From: Martyn White
Sent: 24 February 2015 15:38
To: Planning.Responses
Cc: David Easton
Subject: AW/344/14/HH

**ADC Planning Consultation
Response from the Conservation Officer**

Application Number	AW/344/14/HH
Address	68 The Drive Bognor Regis PO21 4DS
Description	Increase existing single storey side extension, clad external elevations with insulation & render, remove existing clay tiled roof & recover with Welsh slates, 3 No velux windows within the north facing front roof elevation, 32 No new windows, 7 No new doors, reconstruction of first floor balcony, new external steps at rear of side extension, gable roof extension to existing first floor living room & external garden swimming pool.
Case Officer	Mr. D Easton

ROOF PLAN

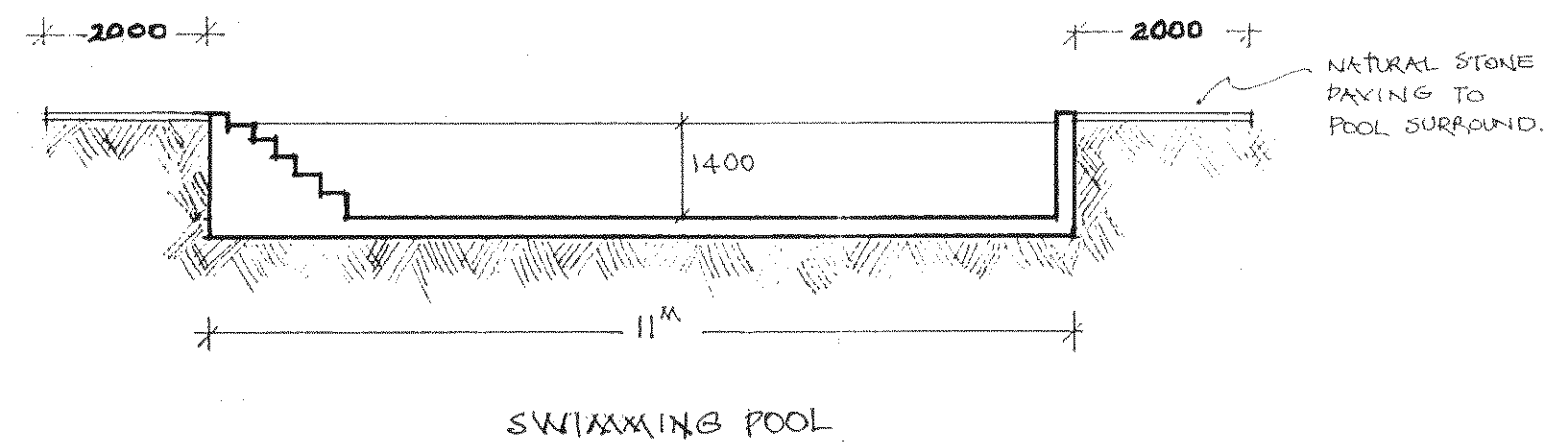
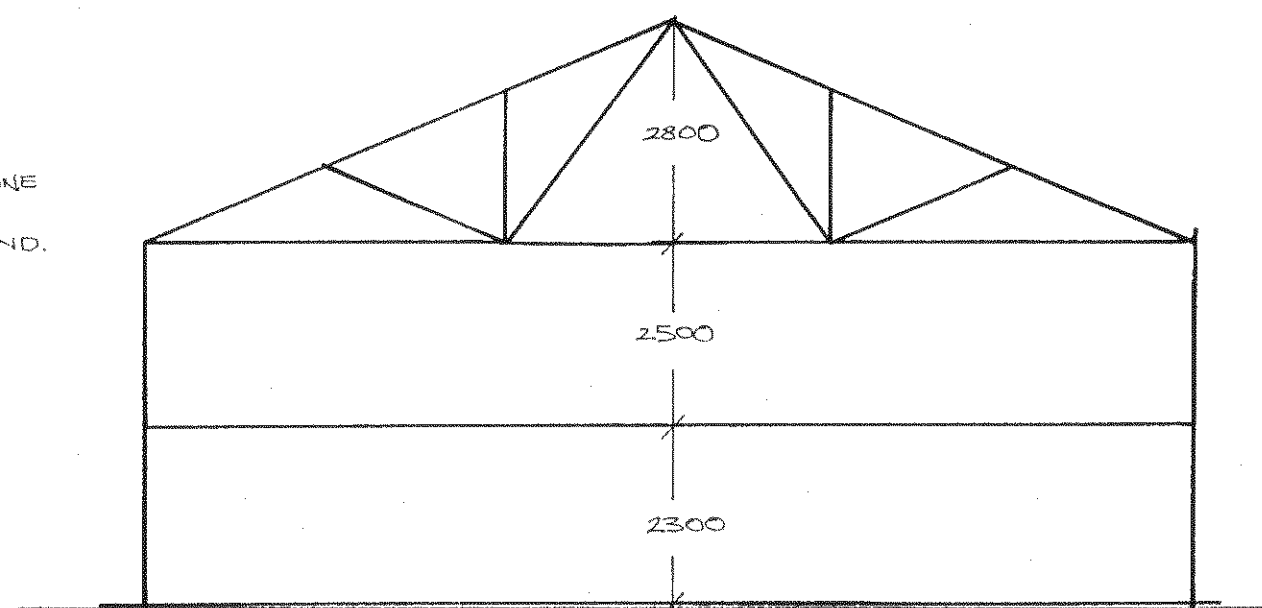
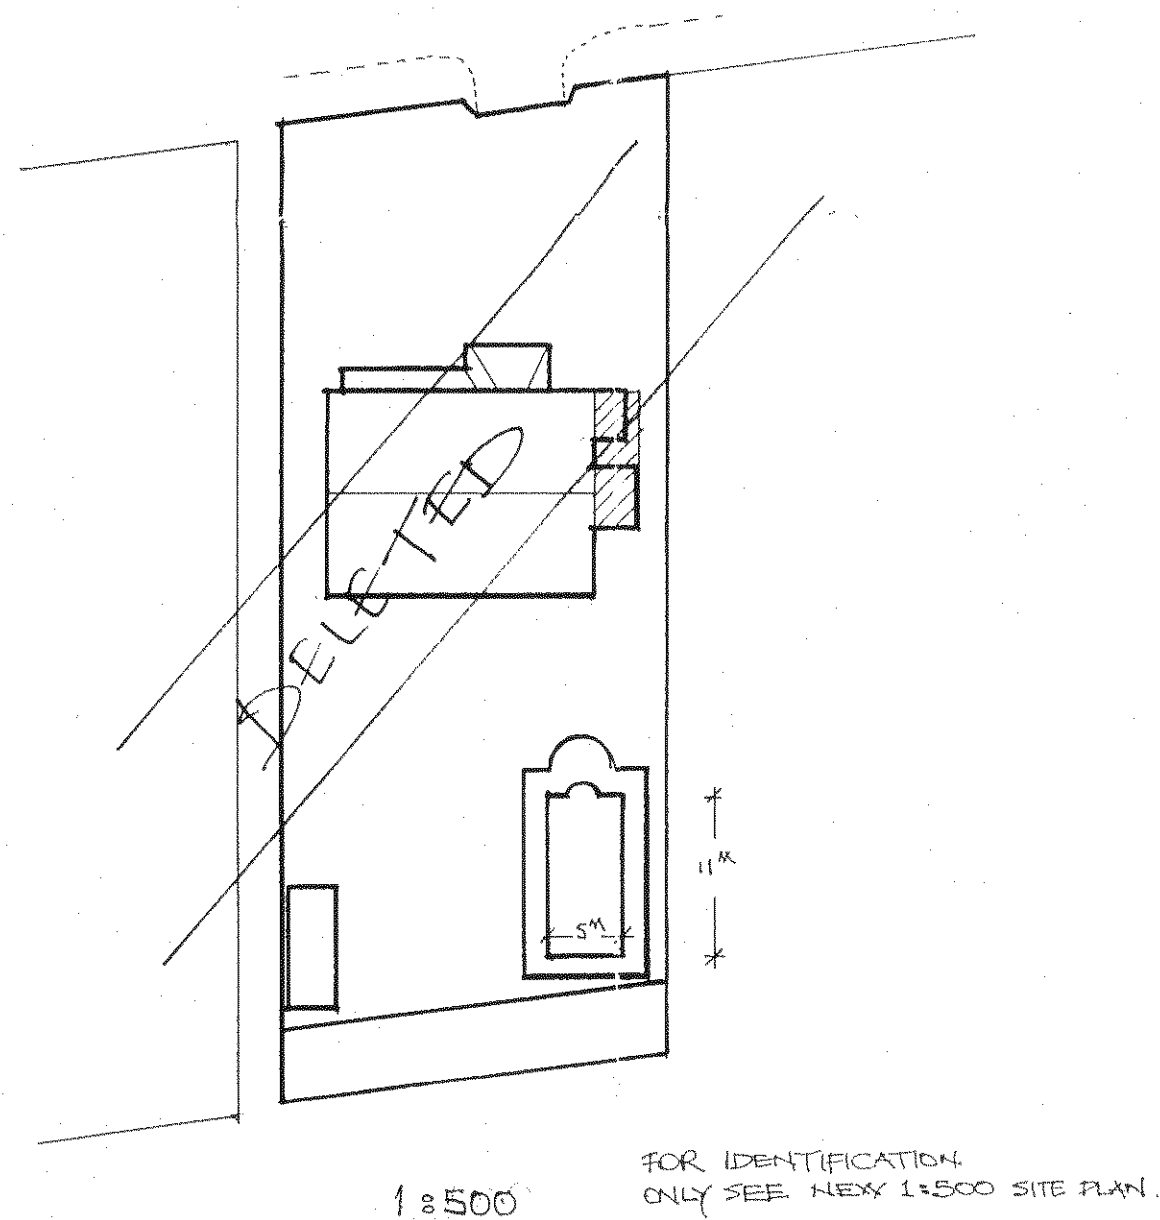
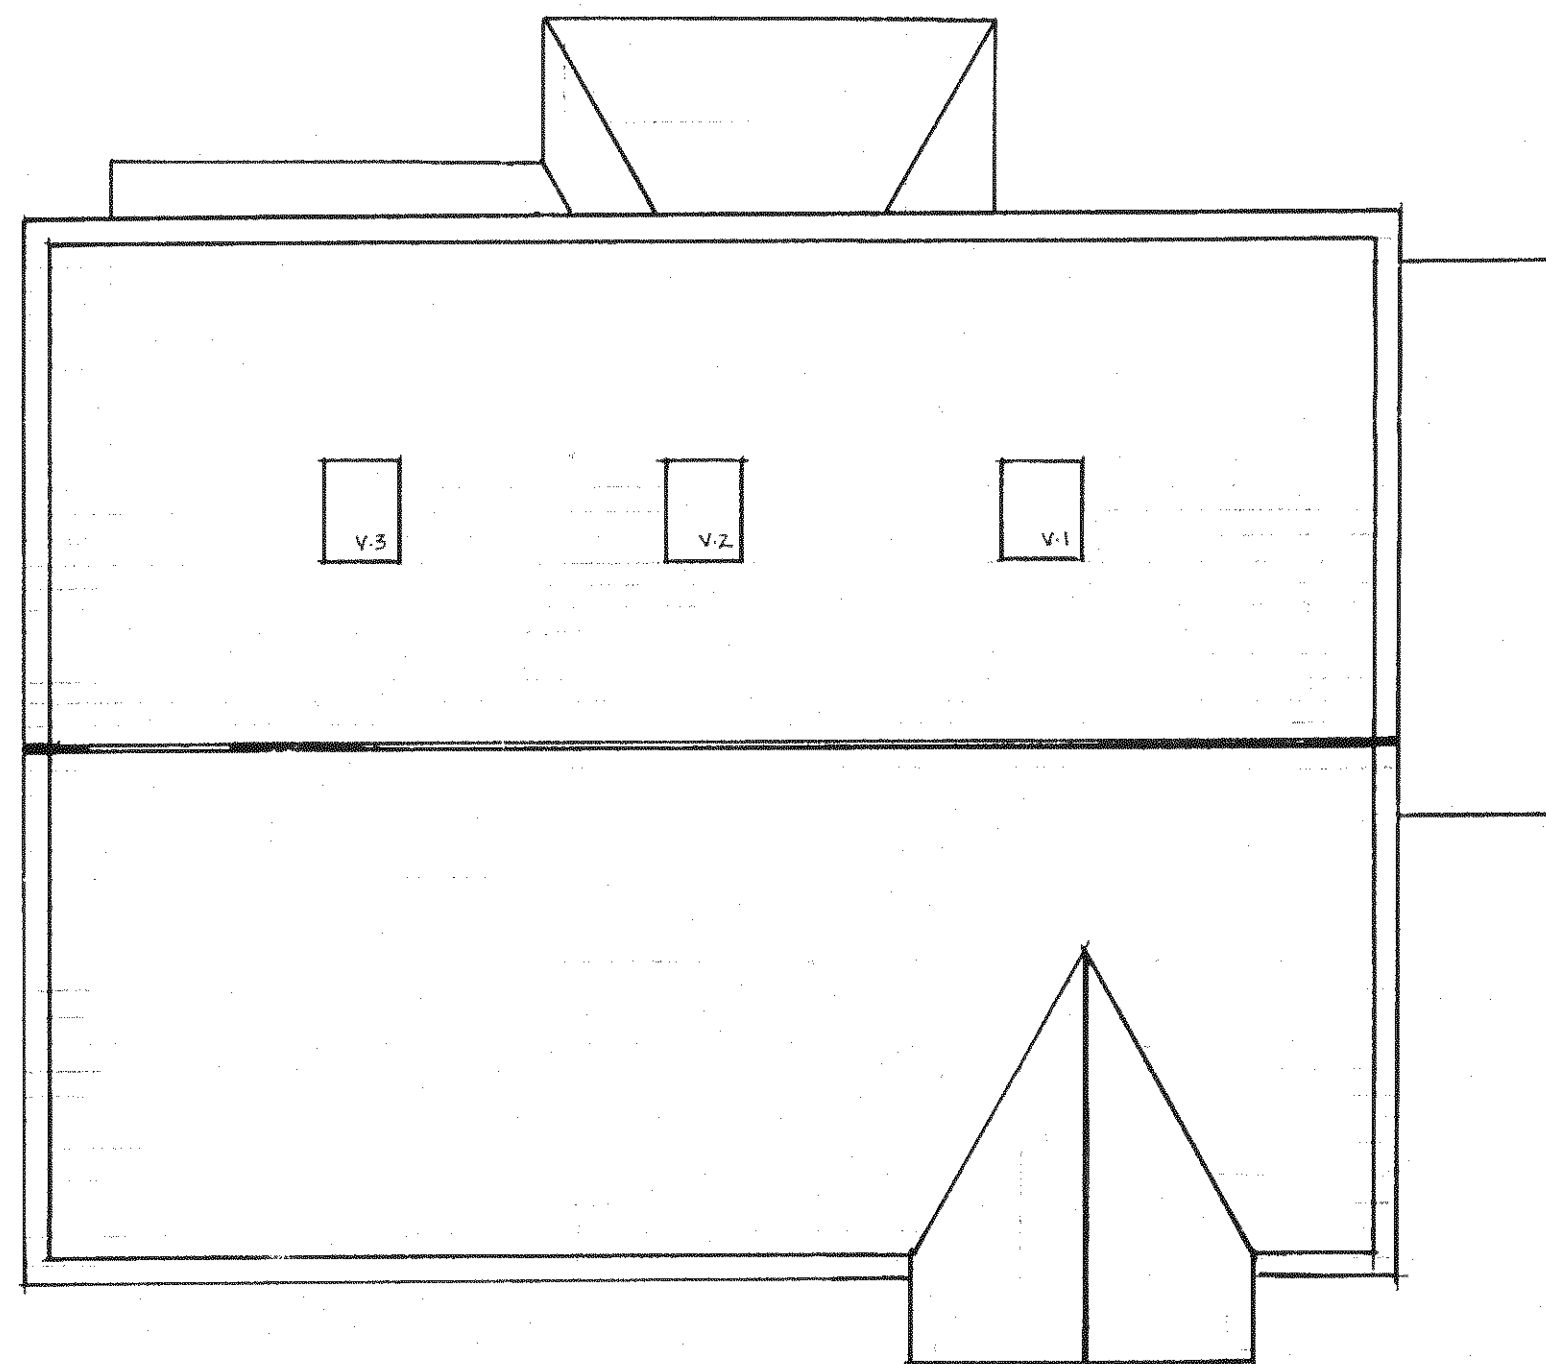
The property is currently constructed in brick and clay roof tiles, in an area where such materials are prevalent. The proposal seeks to introduce alternative materials namely slate roofing. It is considered that this is problematic as such materials do not respect the established characteristics of the locality.

- Conservation Area roof-lights
- Details of the colour of the render
- Details of the replacement balcony

SOUTH & EAST ELEVATIONS
EXISTING & PROPOSED.

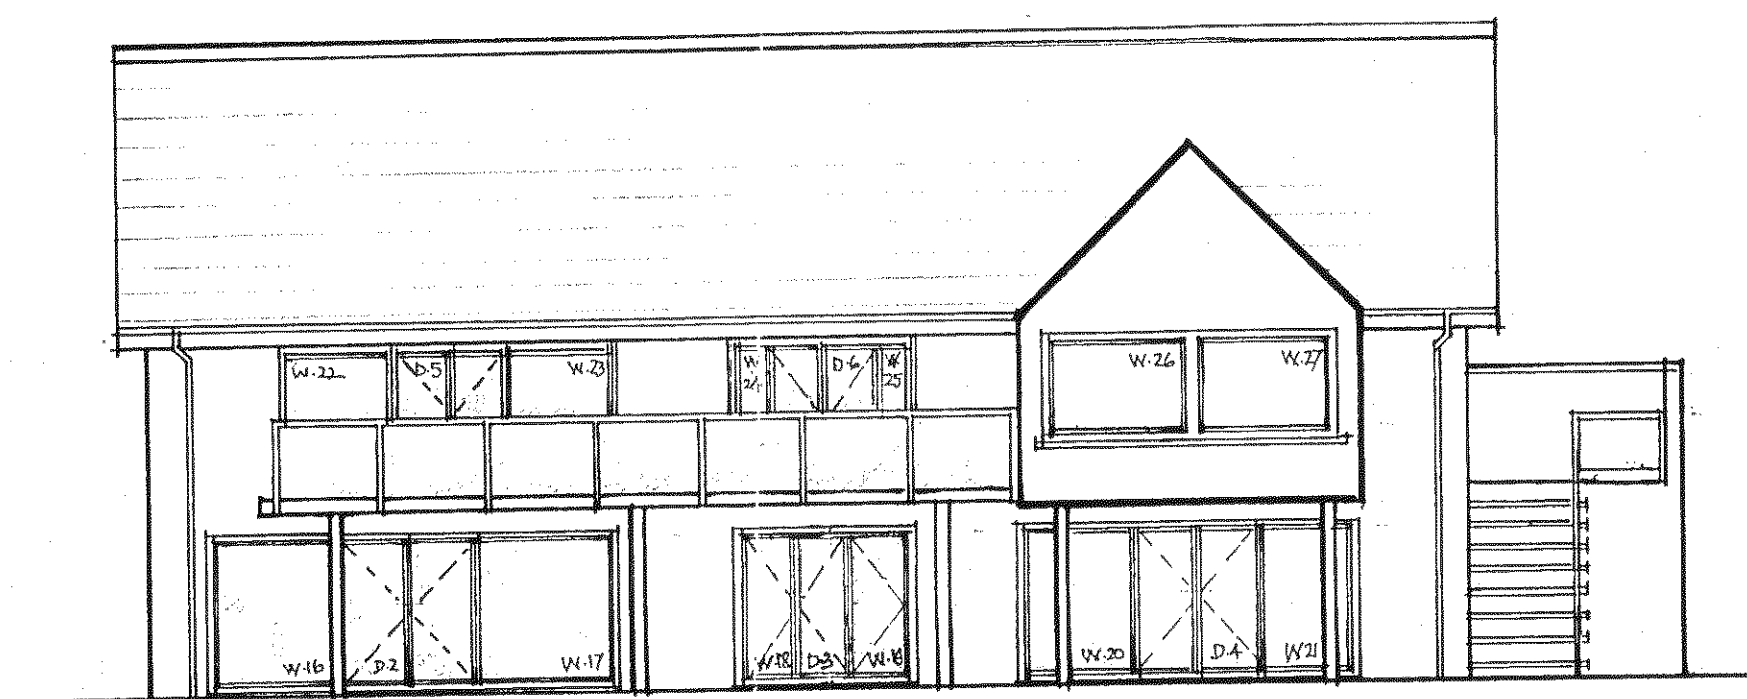
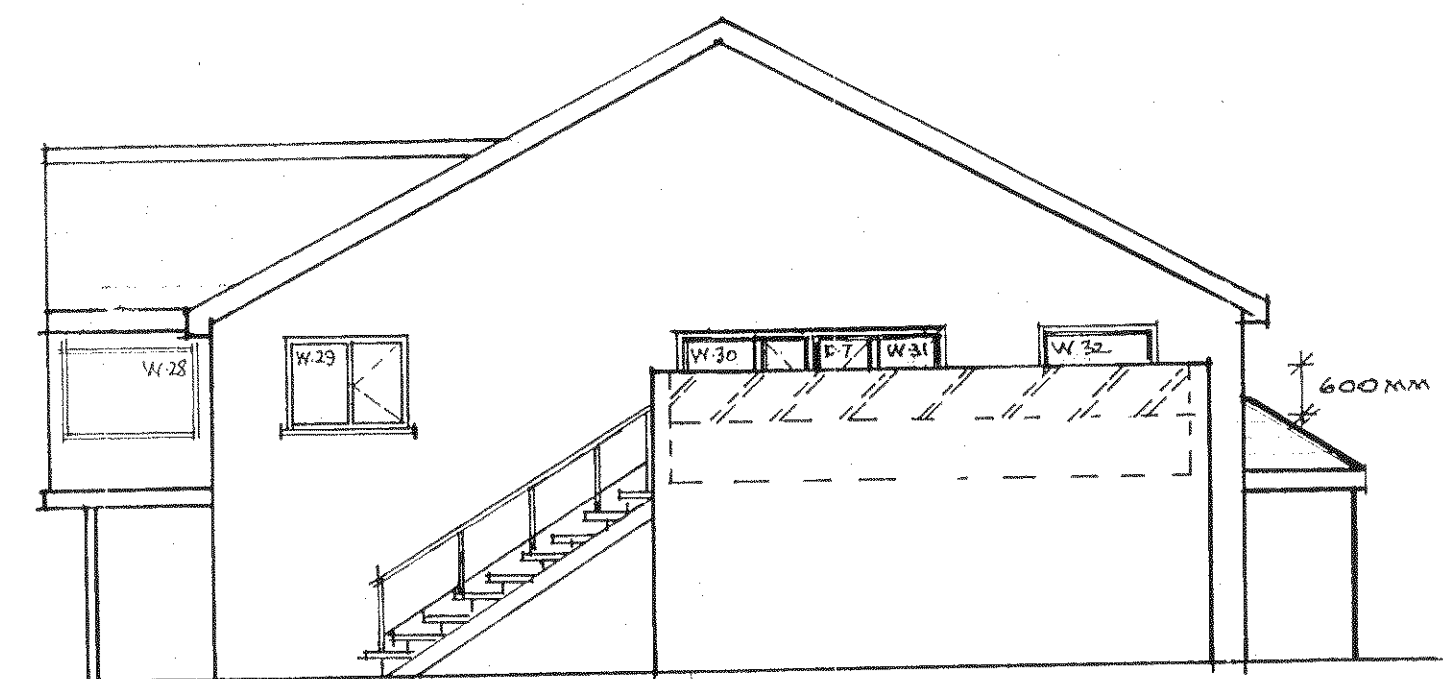
Further, the proposal introduces a revised living room 'bay' window with a revised roof. This increases the prominence of the structure on the rear elevation, which is unfortunate.

The removal of the rear steps and the replacement of the balcony with a larger one constructed with a steel handrail and glass supports, further increases its presence on the rear elevation.
